From: Nolan, Chris <Chris.Nolan@lancashire.gov.uk>
Sent: 16 November 2017 09:43
To: Stephen Kilmartin; planning
Cc: LHS Customer Service
Subject: D3.2017.0453 - Edisford Bridge Farm Edisford Road Clitheroe

Planning Application No: 3/2017/0453

Proposal: Two new signs - one free-standing board advertisement by existing access road and one fascia sign on industrial unit.

Location: Edisford Bridge Farm Edisford Road Clitheroe BB7 3LJ

Entrance/Roadside Advertisement

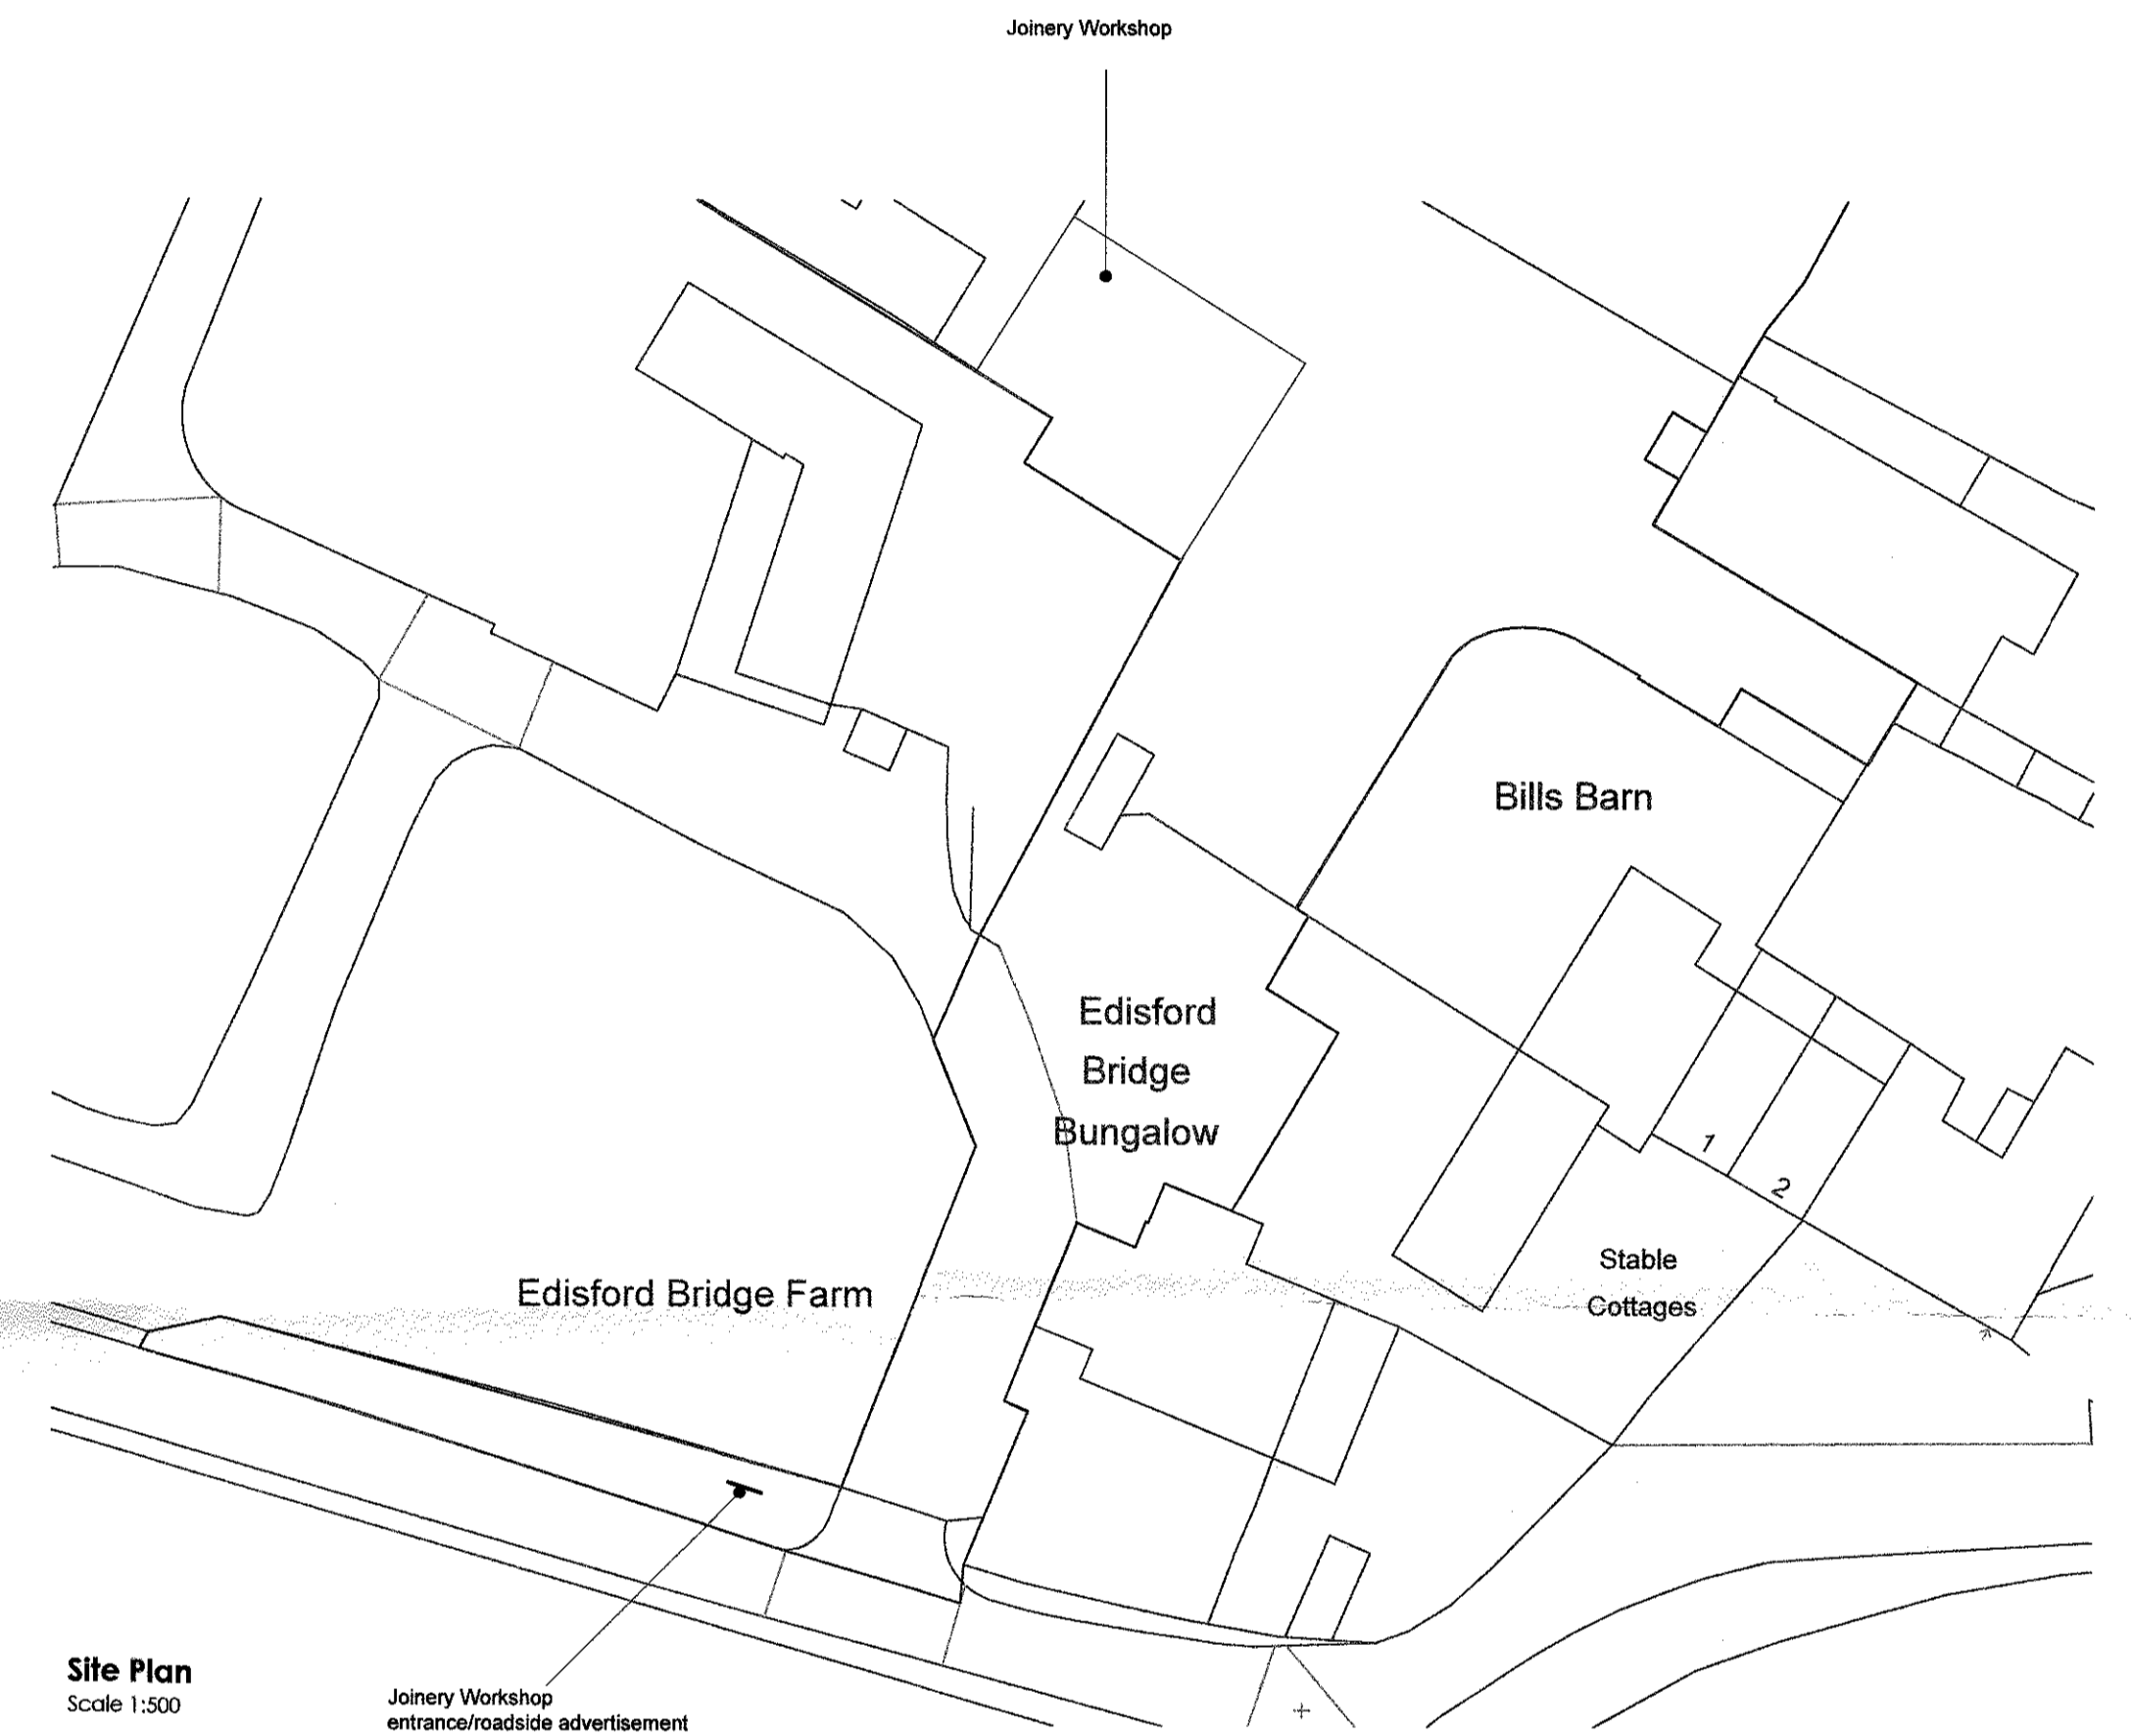
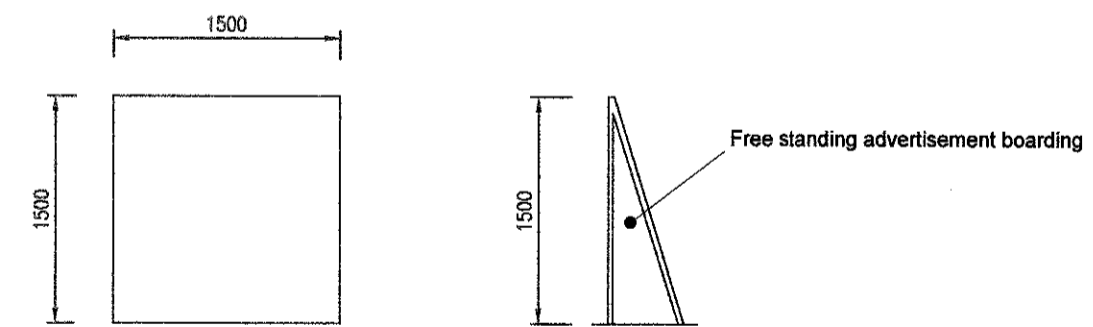
Investigations indicate that a margin of this land is adopted highway I would approximate that this is 1.5m from the edge of the carriageway. As this is highway I would not be able to give permission for a sign on this part of the verge. The whole area is a very well maintained and does form the sightlines for the exit from Edisford Bridge Farm. Sight lines are required for a distance of 2.4m back from the edge of the carriageway and for this part I would say that the height of any vegetation or construction would need to be maintained at less than 1m in height. The proposed sign is 1.5 m tall by 1.5m wide and as long as this is placed against the present fence then it would not cause a problem with regard to obstructing sightlines whilst also not being placed on the highway.

The description of the sign is free standing. It is important that the sign is correctly secured so that in severe weather conditions there is no possibility of the sign being blown from its position into the highway. I would like assurances that this possibility has been resolved in either the design of the sign or the method of securing the sign.

1. The sign is placed at least 2.4m back from the edge of the carriageway of Clitheroe Road, Bashall Eaves. Reason to ensure that the sign does not obscure the sightlines for traffic leaving the Edisford Bridge Farm site.
2. The sign and structure supporting the sign is sufficiently secured to ensure that, as far as practically possible, there is no risk the unit or parts of the unit being dislodged and causing a hazard on to the highway. Reason: Highway safety.
